Our Ref: AW/147/18/HH
Your Ref:

Town & Country Planning Act 1990 (as amended)
Town & country Planning (Development Management Procedure) (England) Order 2015
Application for Planning Permission for Works or Extension to a Dwelling

Development Single storey rear extension.
Location 29 Fernhurst Gardens Bognor Regis

ELEVATIONS [AS EXT.]				
Scale	1:100		Drawn By	C.R.B.
Date	MAR 18		Checked	
Drawing Number		1490-3

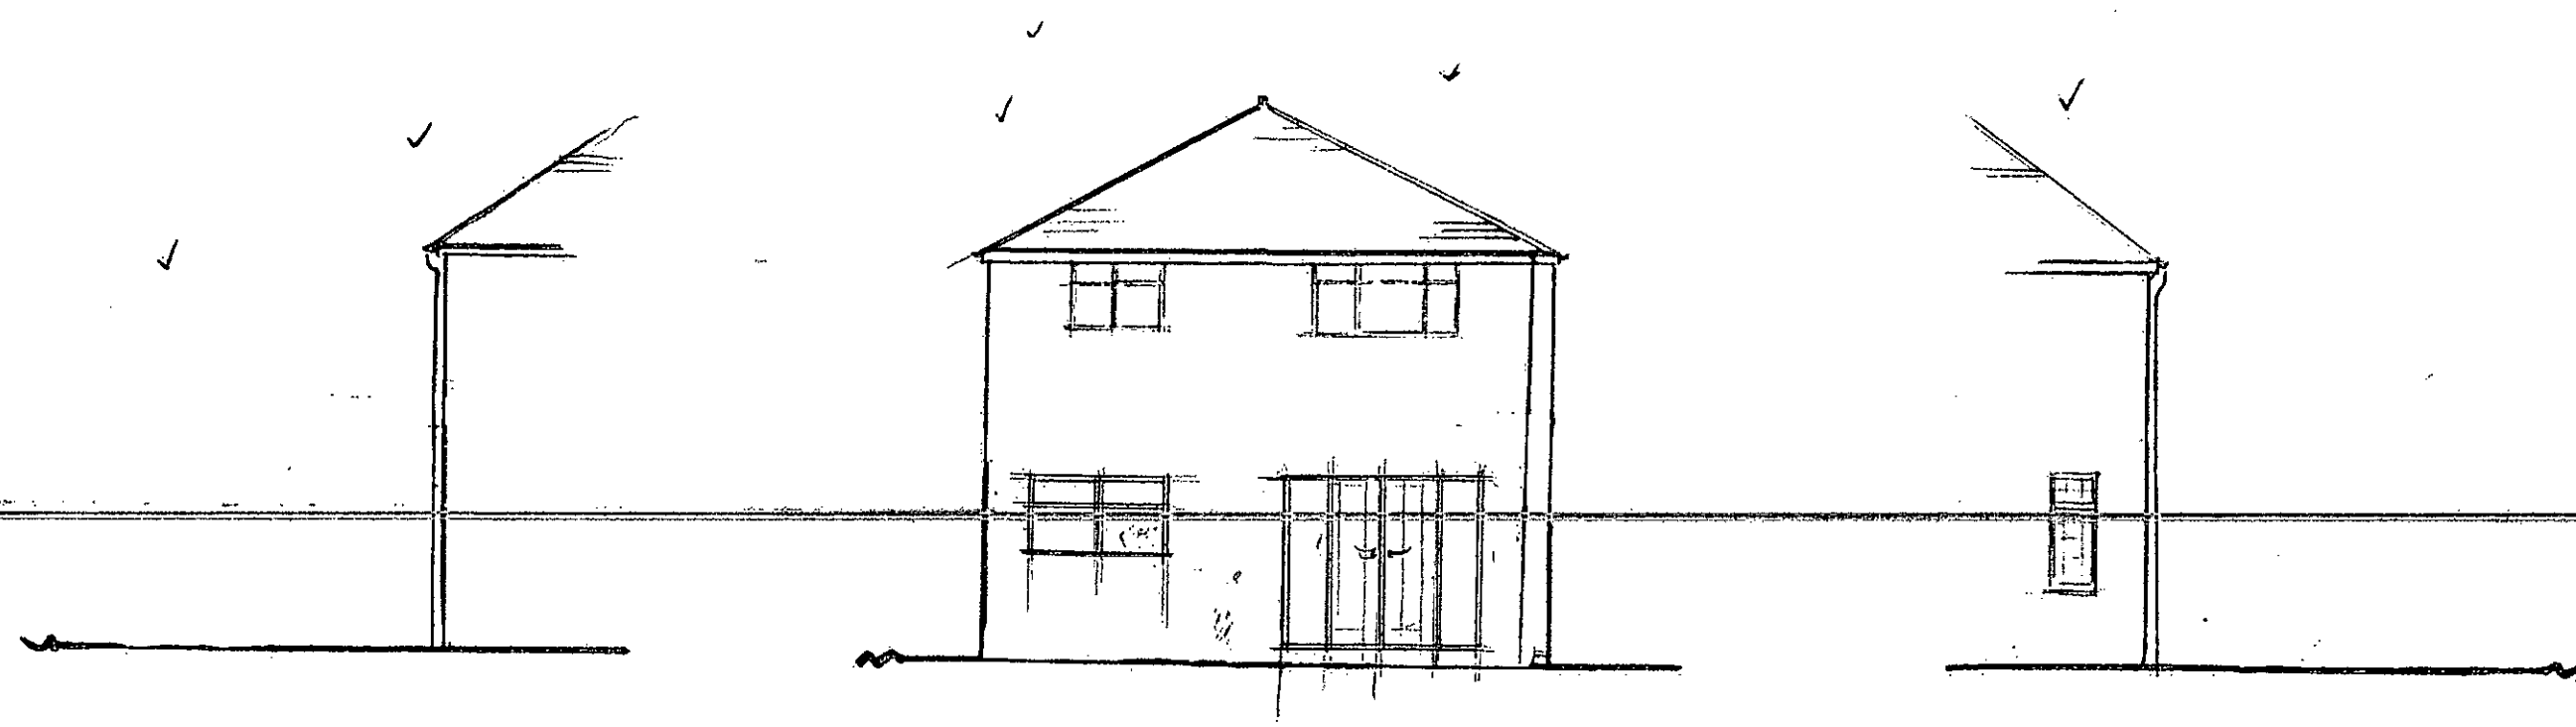
The existing north floor plan and elevation do not accord. Please amend accordingly.
